MIAG and Mcl PC written submissions from oral presentation;

Traffic; Junction 24;

MIAG – Comments on re-designed Inworth Road Roundabout

01-03-2023

Drawing title: ENGINEERING SECTIONS (PLAN AND PROFILES) JUNCTION 24 SHEET 1 OF 5

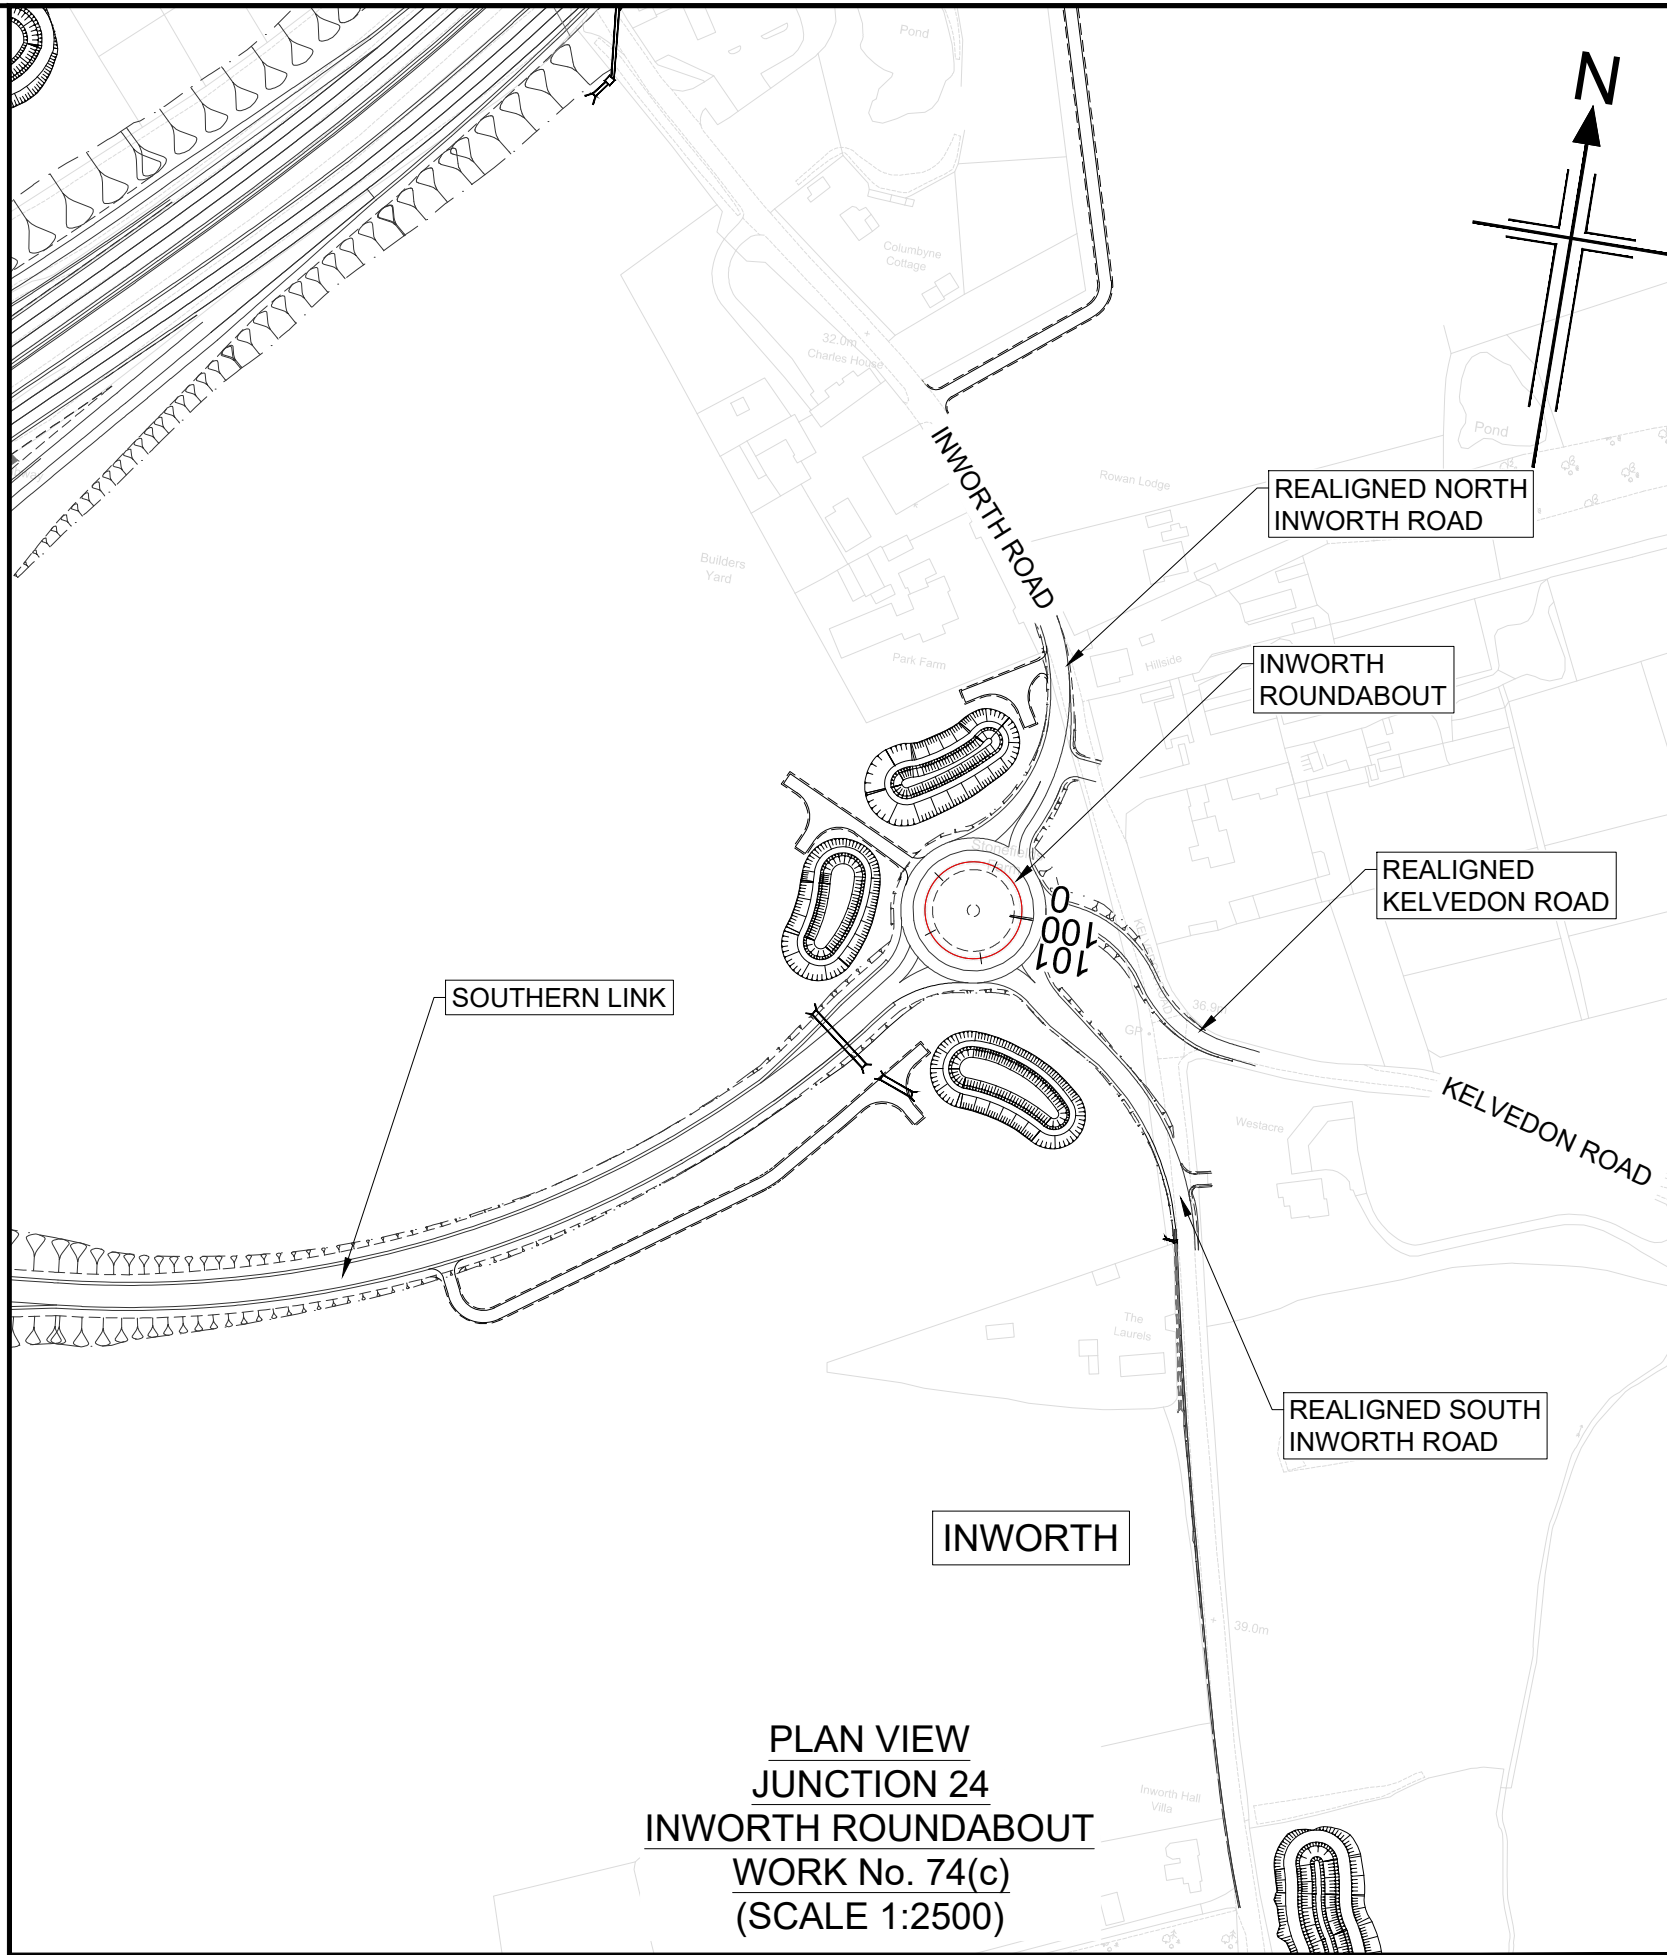
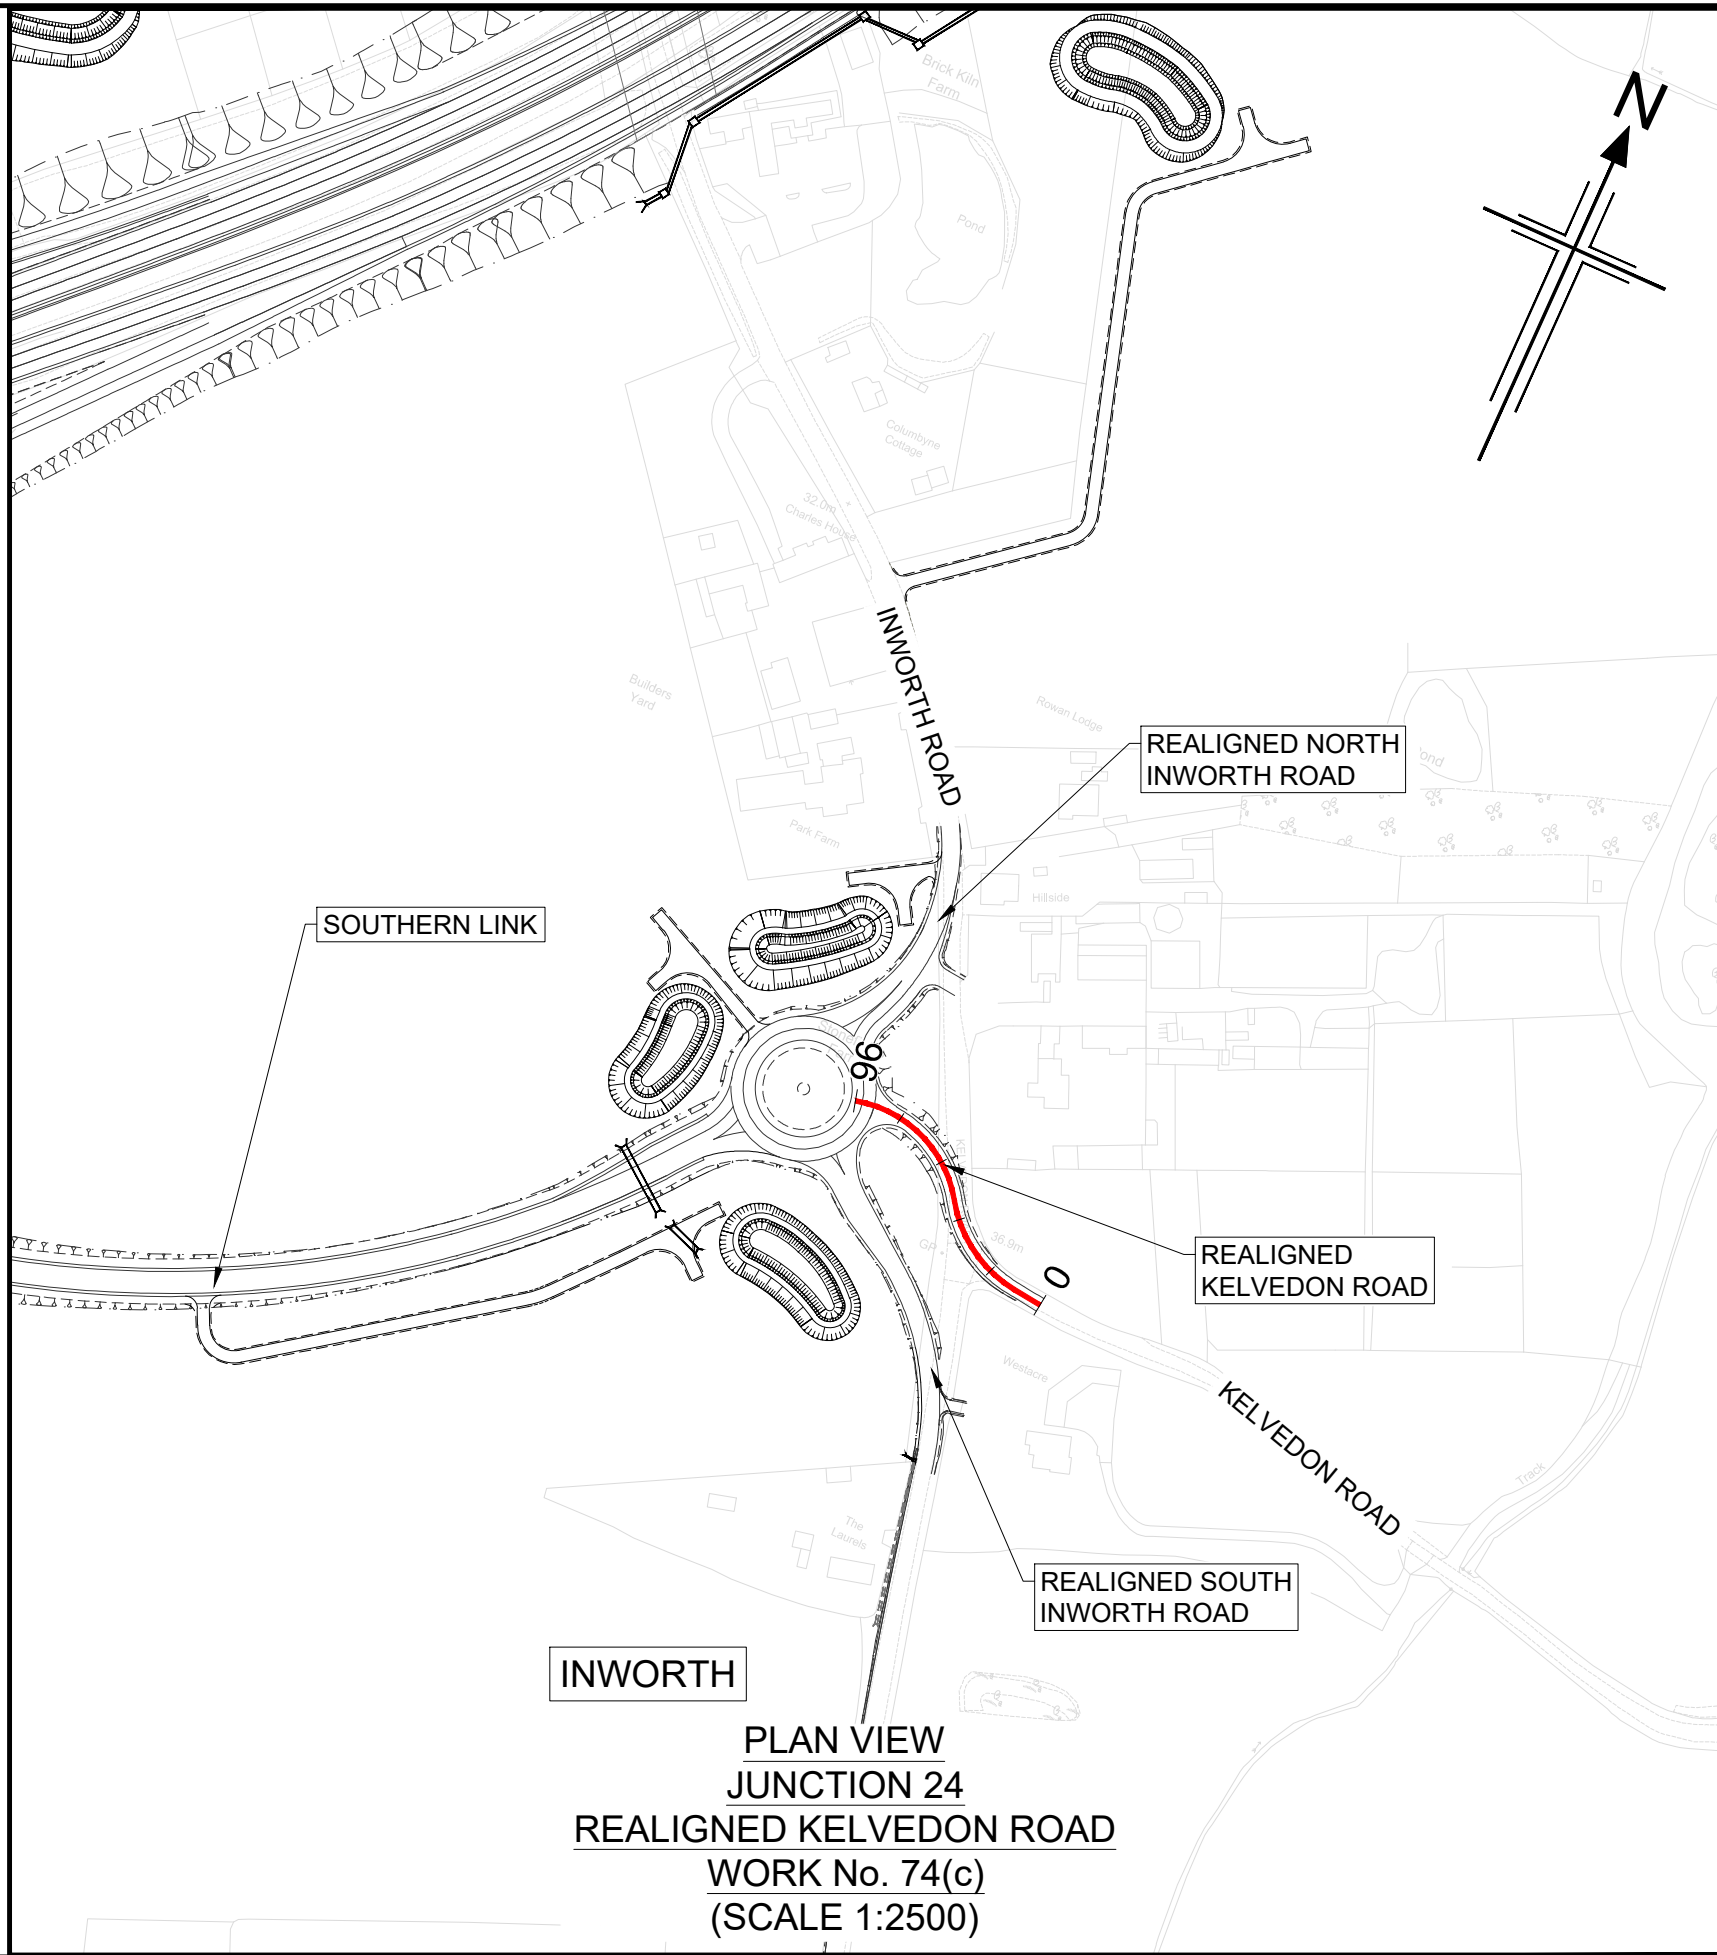
5. It is noted that the northern arm of the roundabout connecting to Inworth Road has an SSD that falls below 33m as a result of the existing wall surrounding Park Farm, which extends into the verge and would prevent visibility of the 'low object' of 0.26m height.

This re-design removes the largely redundant Segregated Left Turn Lane, which did not comply with Design Manual for Roads and Bridges standards in any case. There is also a variation in the geometry of the Inworth Road north approach arm. The centreline horizontal radius of 67.5 m has been increased to 75.0 m compared to the design submitted in the DCO application.

MIAG are concerned about the low values of SSD on the approach to and exit from the roundabout. The arm connecting to Inworth Road north of the roundabout is of particular concern and MIAG do not feel confident that even the value of 43m SSD has been achieved for this arm. In fact, the proposed back of verge and earthworks appear to encroach into the Park Farm boundary. SSD checks carried out by NH only continue to as far as the tie in of the new works with the existing Inworth Road. This does not show the full effect of the new works on SSD. If SSD checks are continued further along Inworth Road a 43m SSD line would be obscured by the existing brick wall on the boundary of Park Farm (Figure 1.). Over this length visibility values, at 5m intervals were measured, the results were as follows: 40.5m, 37.2m, 34.2m, 32.3m, 33.2m (Figure 2.). This would indicate a length of about 30m of the alignment where the claimed 43m SSD is not achieved. What makes this more worrying is that there is an entrance to Park Farm immediately following this reduction in available visibility. This would make access and egress extremely hazardous for residents of Park Farm when vehicles approaching after leaving the roundabout will have very little forward visibility.

The application of super-elevation does not appear to have been considered for any of the arms of Inworth Road Roundabout. For the arms that use low values of horizontal radius the values of super-elevation would need to be the maximum advised value of 7% for a rural road (or 5% for an urban street). Radii of 75 m for Inworth Road north arm, 90 m for Inworth Road south arm have been used. DMRB standards would require the maximum value of 7% super-elevation to be applied to radii of 75 m and 90 m for a rural road. Application or changes in super-elevation would normally be provided over the length of transition curves connecting straight or circular curved elements of a horizontal alignment. In this design no transition curves have been provided, therefore the advice of DMRB is to apply between half and two thirds of the super-elevation on the approach straight and the remainder on the circular arc.

No approach straight has been provided for Inworth Road north arm at the tie in to the existing road. The minimum length of application of super-elevation was calculated to be 30.4 m, this being the shortest length of application and assumes a linear change in gradient of the outer channel and the road centre line of a constant 1% (a reverse curve profile could be used but would double the length of application to 60.8 m). Ideally an approach straight of about 20m length would need to be added to the alignment so that two thirds of the super-elevation can be applied before the beginning of the circular arc. Figure 5, below, shows the extents of the 7% super-elevation that can be applied on the approach to the roundabout.

At the roundabout end of the alignment +7% super-elevation would need to be reduced to -2% before the roundabout give way line. As the carriageway is wider at this end of the alignment the length of application of super-elevation will increase. The length to apply a change from +7% super-elevation to -2% cross fall at the give way line was calculated to be 47 m. This change in superelevation would occur mostly where the centreline horizontal radius is 75m and would leave less than 20 m length of this curve with the required 7% super-elevation. This is always a problem when approach arms to a roundabout are not designed with straight or near straight horizontal alignments.
